Development Facilitation Team (DHO) – Review Comments

Project No: PR-2023-008767 Date: 10/25/2023 Agenda Item: #13 Zone Atlas Page: L-22, L-23
Legal Description: Lot/Tract J-1, Four Hills Village Shopping Center, and Apartment Complex
Location: 200 Tramway Blvd SE between Tramway Blvd and Central Ave.

Application For: SD-2023-00180 – PRELIMINARY/FINAL PLAT (DHO)

Application For: VA-2023-00306 – SIDEWALK WAIVER (DHO)

**Plat for  
Tracts J-1-A and J-1-B, Four  
Hills Village Shopping Center  
and Apartment Complex  
Being Comprised of  
Tract J-1, Four Hills Village Shopping  
Center and Apartment Complex  
City of Albuquerque, Bernalillo County, New Mexico  
August 2023**

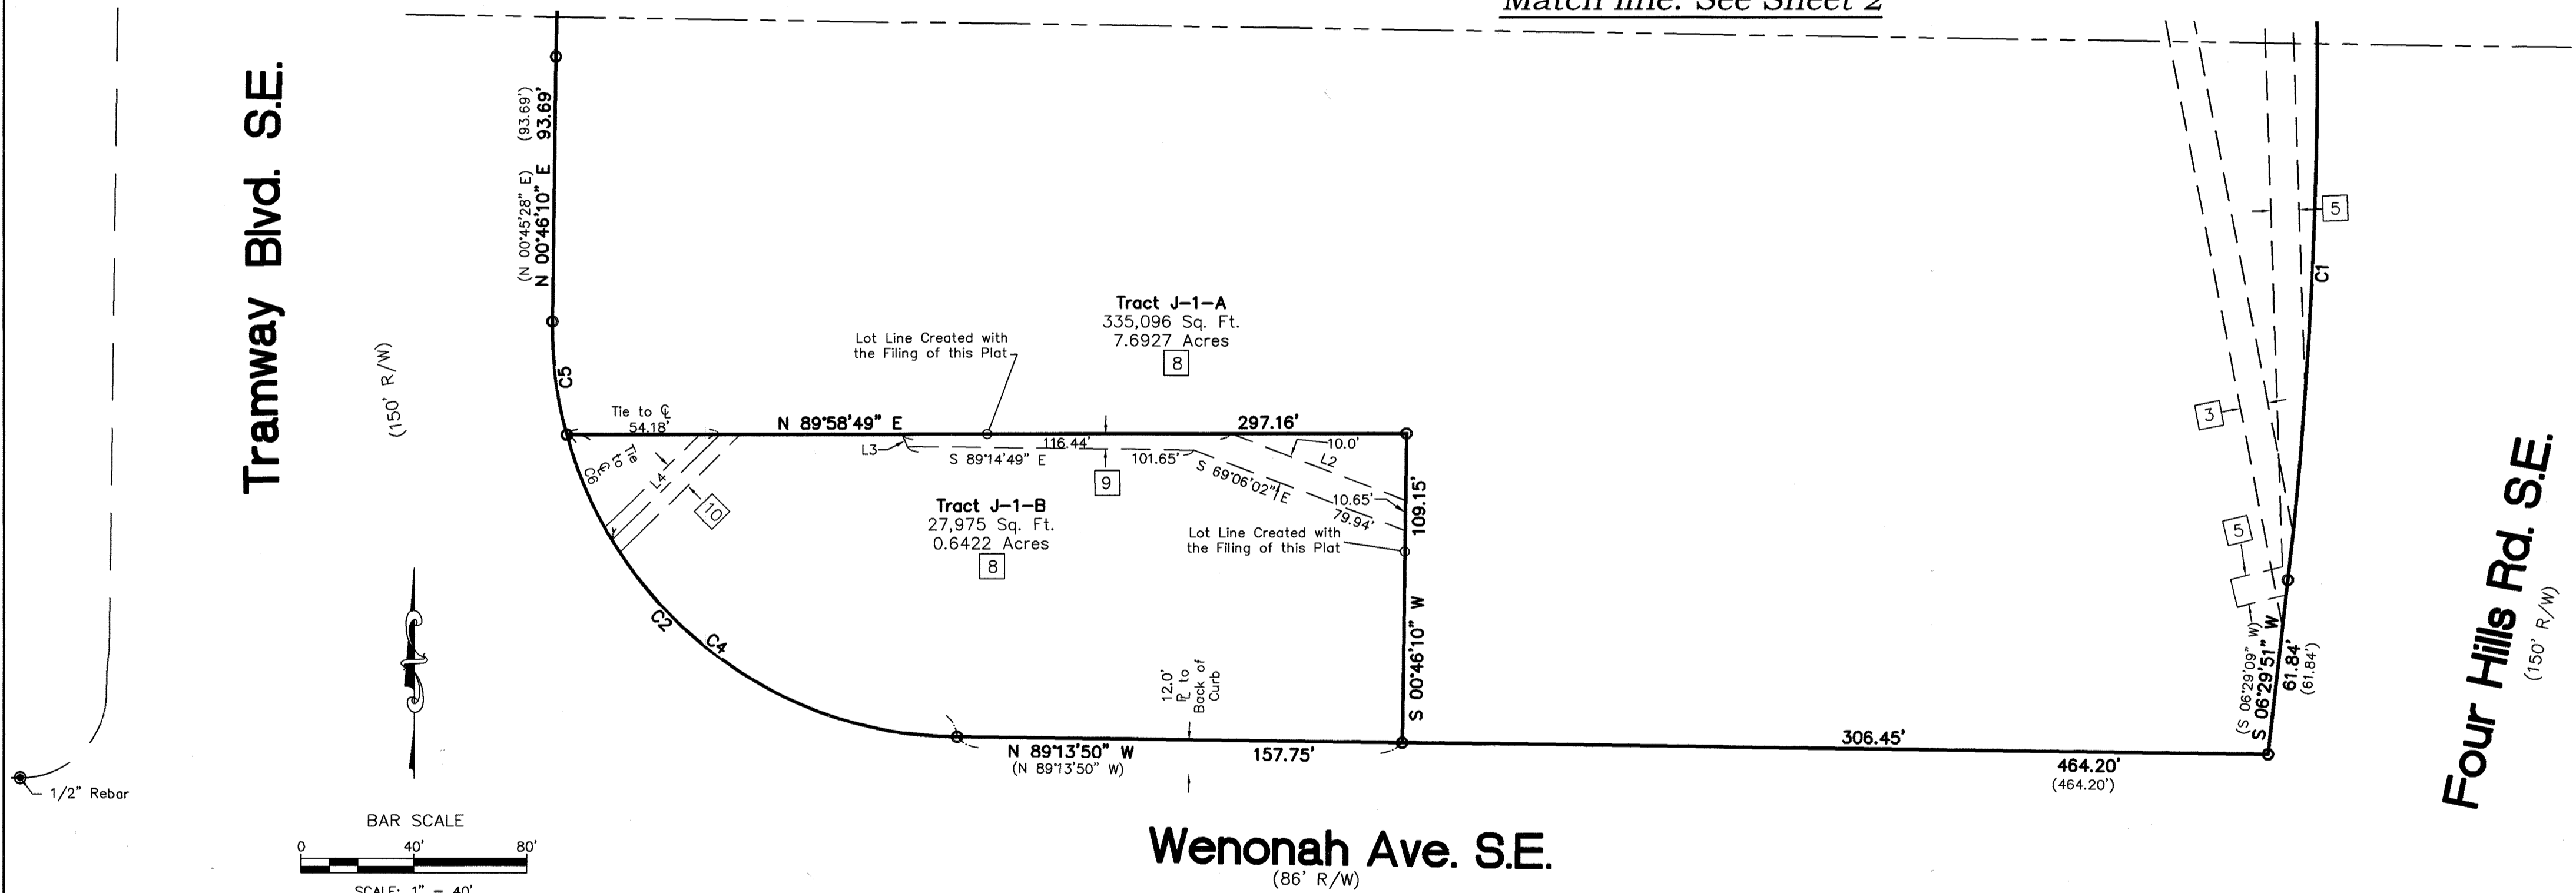
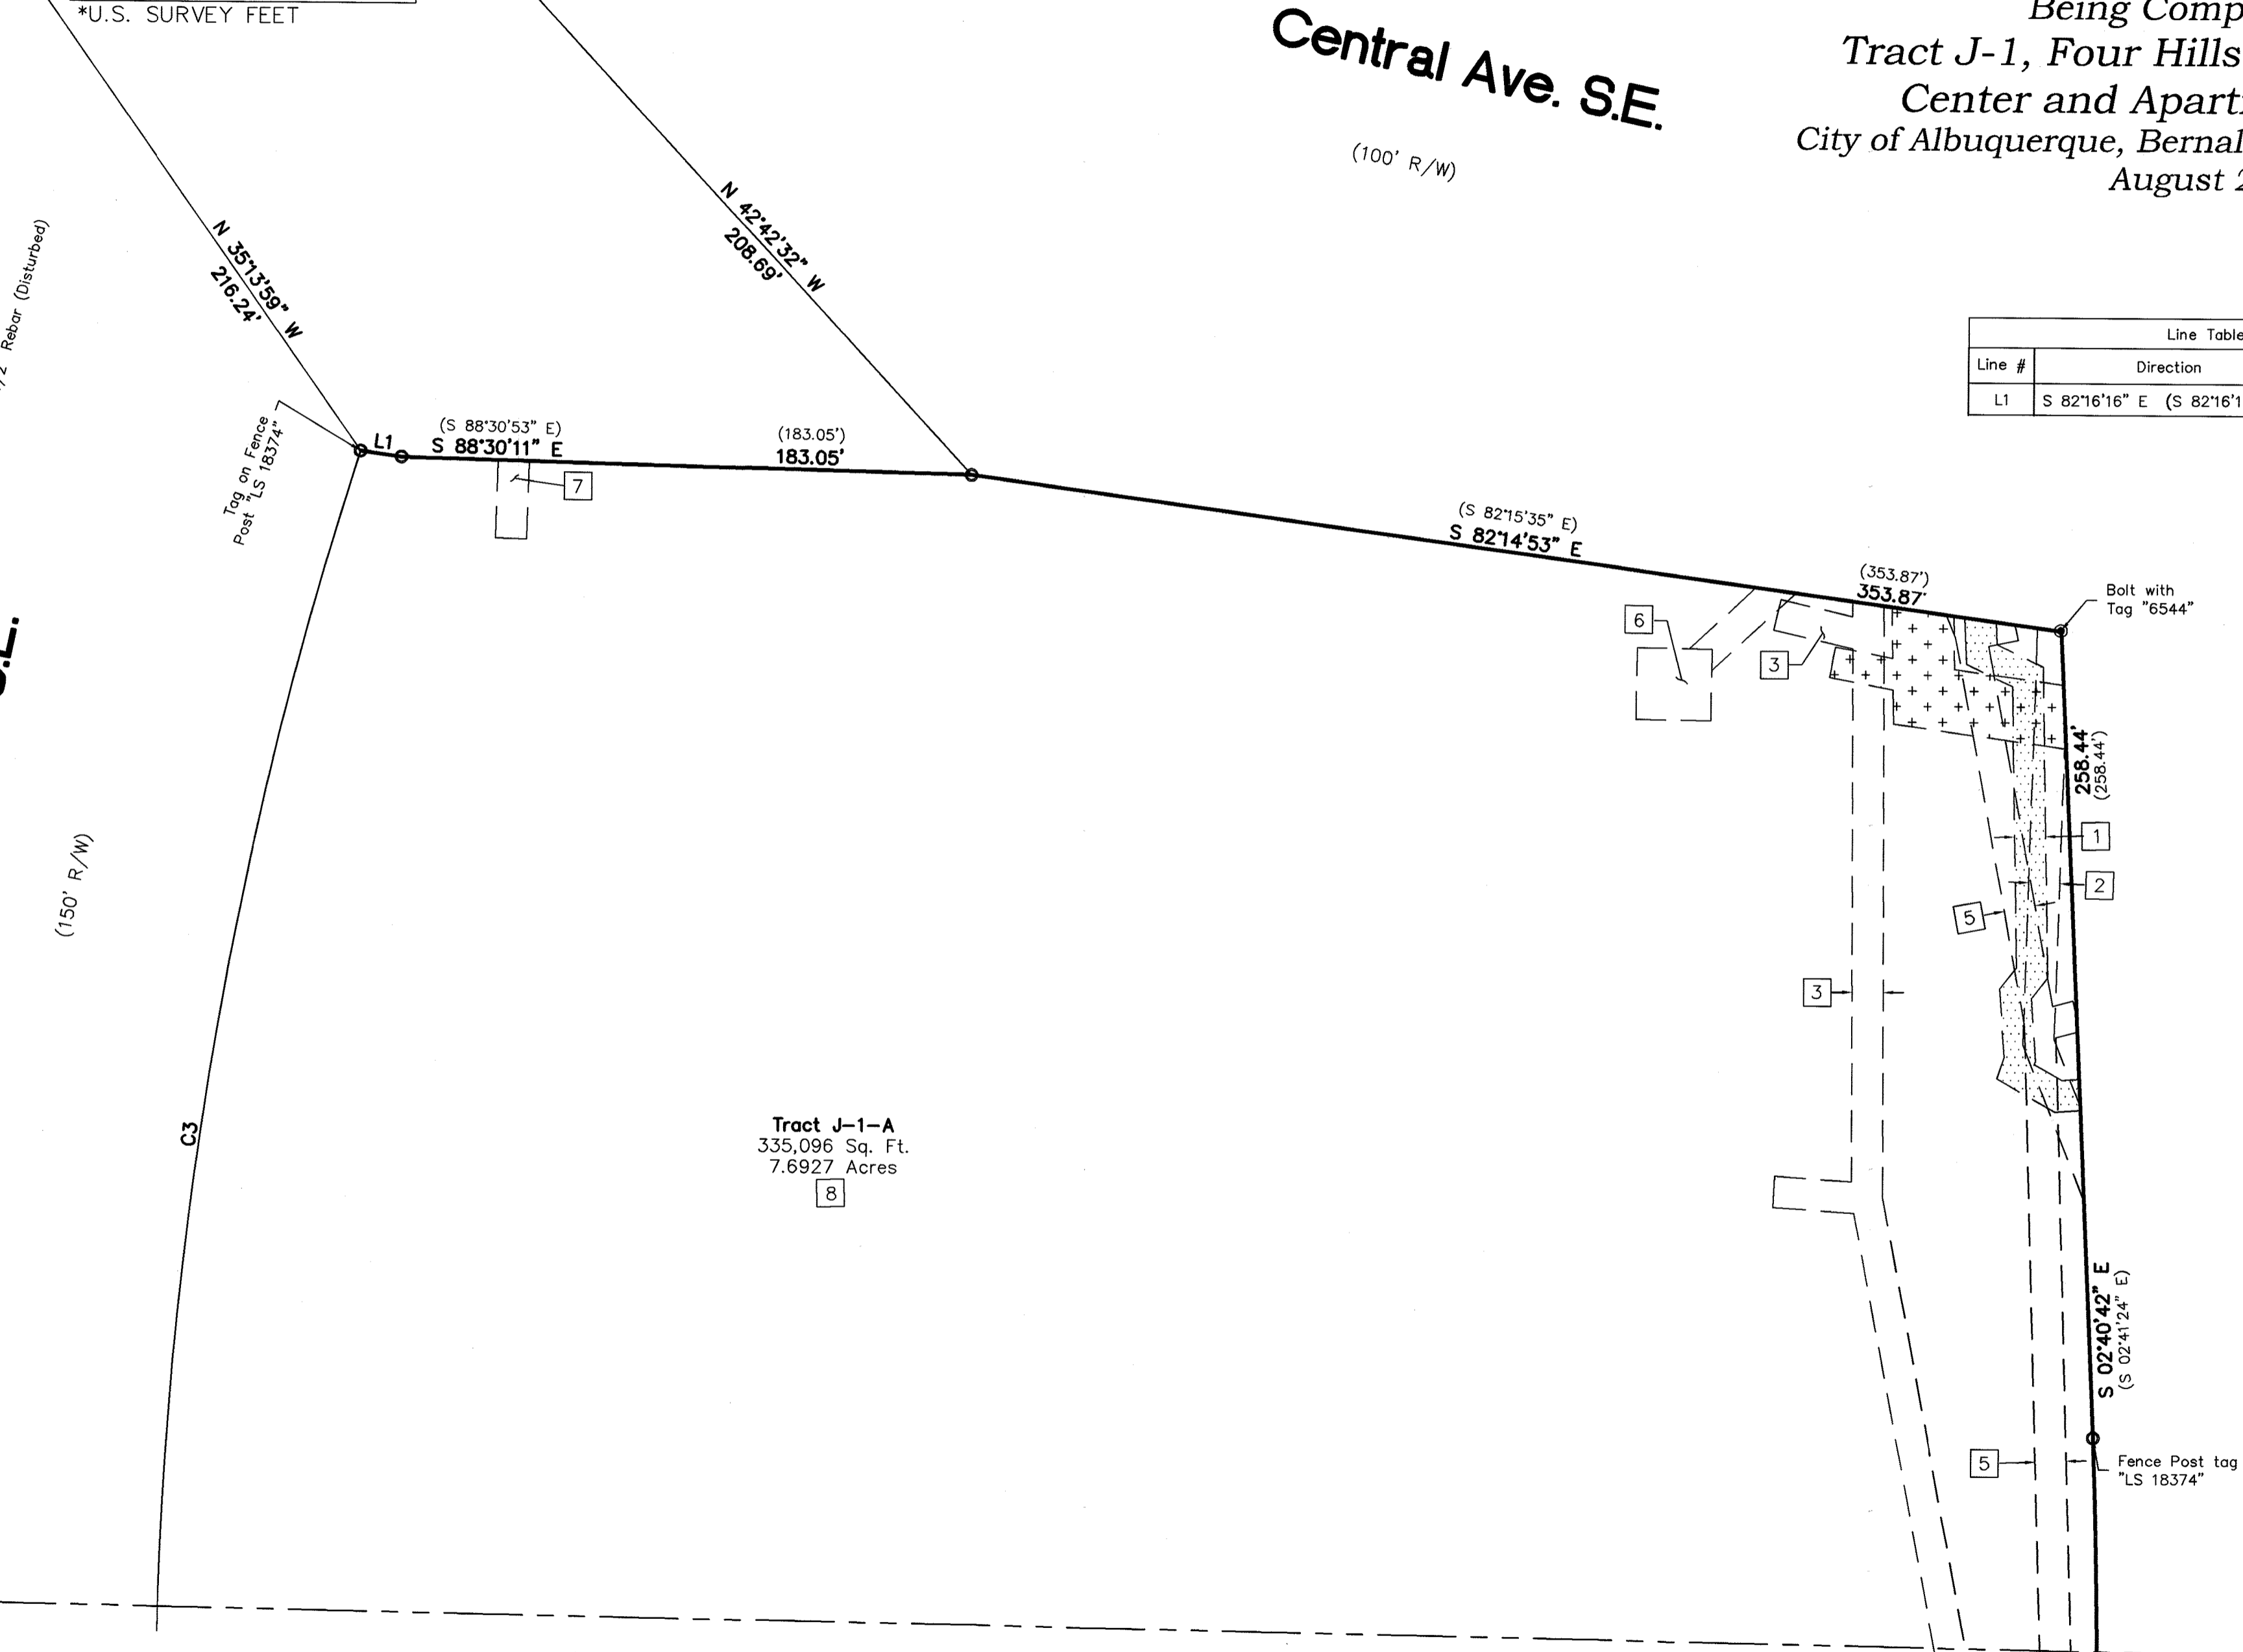
- **Please confirm ROW development detail and the compliance of section 7 of the DPM, Table 7.2.29. In regards to Sidewalk width requirements and its landscape buffer.**
***A sidewalk waiver has been submitted with justification letter.**
***Standards per Transportation**—Transportation is satisfied with the justification for the waiver.
*The site is located in the Four Hills Village **Activity Center** along Central Ave. and Tramway Blvd. Also within an MT-Major Transit Corridor.*
Tramway and Wenonah are major collectors within a center and therefore require 10' sidewalks
 - **Per 6-6(L)(2)(d)(7) of the IDO, the date of the DHO approval and any sidewalk waiver shall be noted on the Plat.**
 - Per CABQ Transit, the platting action and site plan will not affect Transit locations in the area.
-
